DELEGATED DECISION

Item No.	Report of the Head of Planning, Transportation and Regeneration
Address	SW ADJACENT JUNCTION PUMP LANE/ SILVERDALE RD HAYES
Development:	Proposed 15.0m Phase 8 Monopole C/W wraparound cabinet at base, 3 cabinets and associated ancillary works (General Permitted Development) Order 2015 for determination as to whether prior approval is required for siting and appearance)
LBH Ref Nos:	76044/APP/2020/3862

Title: 210 PROPOSED H3G SITE PLAN

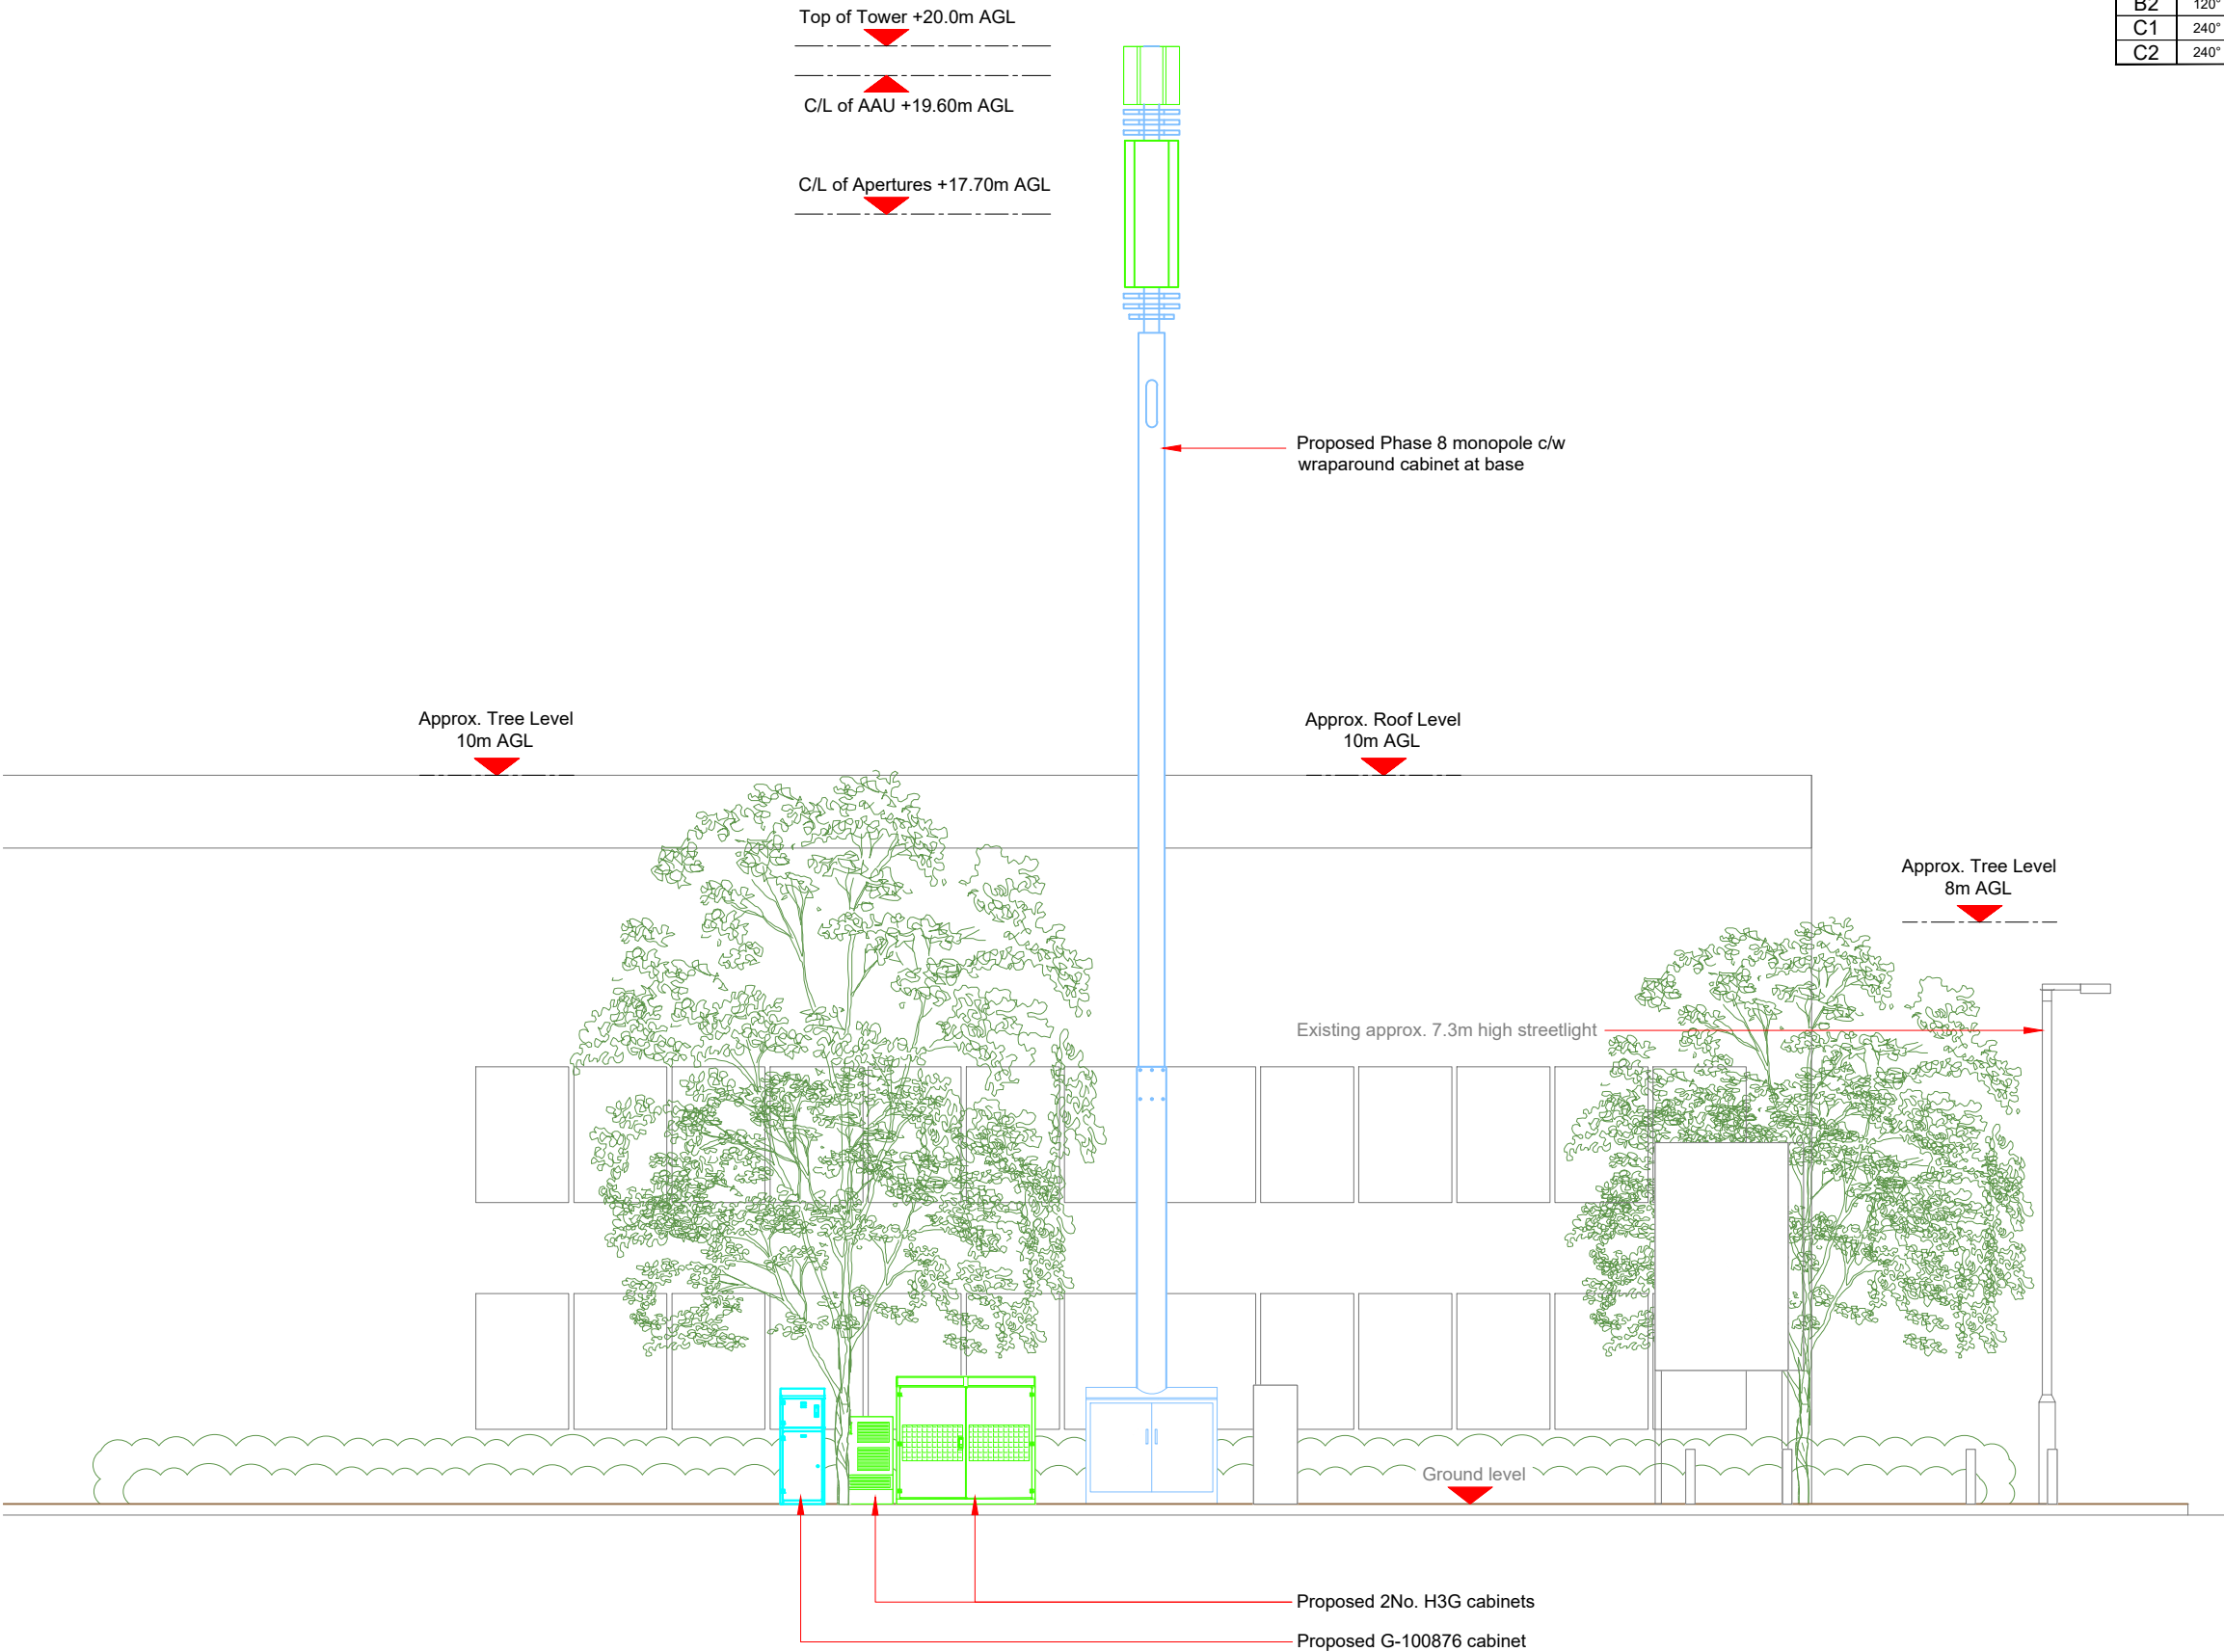
given its site context, there would be limited impact on the character and appearance of the area. However, the location of the cabinets is considered inappropriate and will introduce urban clutter to the footway and otherwise attractive landscape feature.

The application site is located on the paved pedestrian footpath and there is a tree located 3.47m to the east of the monopole with a base cabinet. According to the Arboricultural Impact Assessment, the monopole with the base cabinet is located within the root protection area (RPA) of the tree, referred as T3. The report states that the tree is a common lime with a height of 10m in good condition (category B1 under BS 5837) with estimated remaining contribution as long.

In order to accommodate for the telecommunication equipment, the proposed development would involve the tree to be prune by not more than 1.4 m on the western side and that pruning may be required to maintain distance away from the mast in the future as the tree increases in size. However, the applicant has fail to mention any long-term implementation of maintenance.

The report also states that the "installation of the foundations for the equipment would include some works at the edge of the Root Protection Area of T3, these are expected to be tolerable to the tree because of its age, the distance from the tree, and the availability of better rooting space in the soft verge than beneath the pavement". Based on the plan provided, it shows nearly the entirety of the monopole with the base cabinet is within the Root Protection Area.

The Council's Trees/Landscape Officer have assessed this application and raised objection to the proposal. Due to the close proximity and cabinet's location within the Root Protection Area, concerns are raised on the existing root structure and the plan indicates

that this will unbalance the crown of the tree and spoil its form. The officer has emphasized that until excavation takes place, the full impact of the proposal on the existing root structure cannot be known. Given the above, the existing street tree would be unsustainable with several details which could adversely affect the tree in the medium to long term and will jeopardize the future of a public asset.
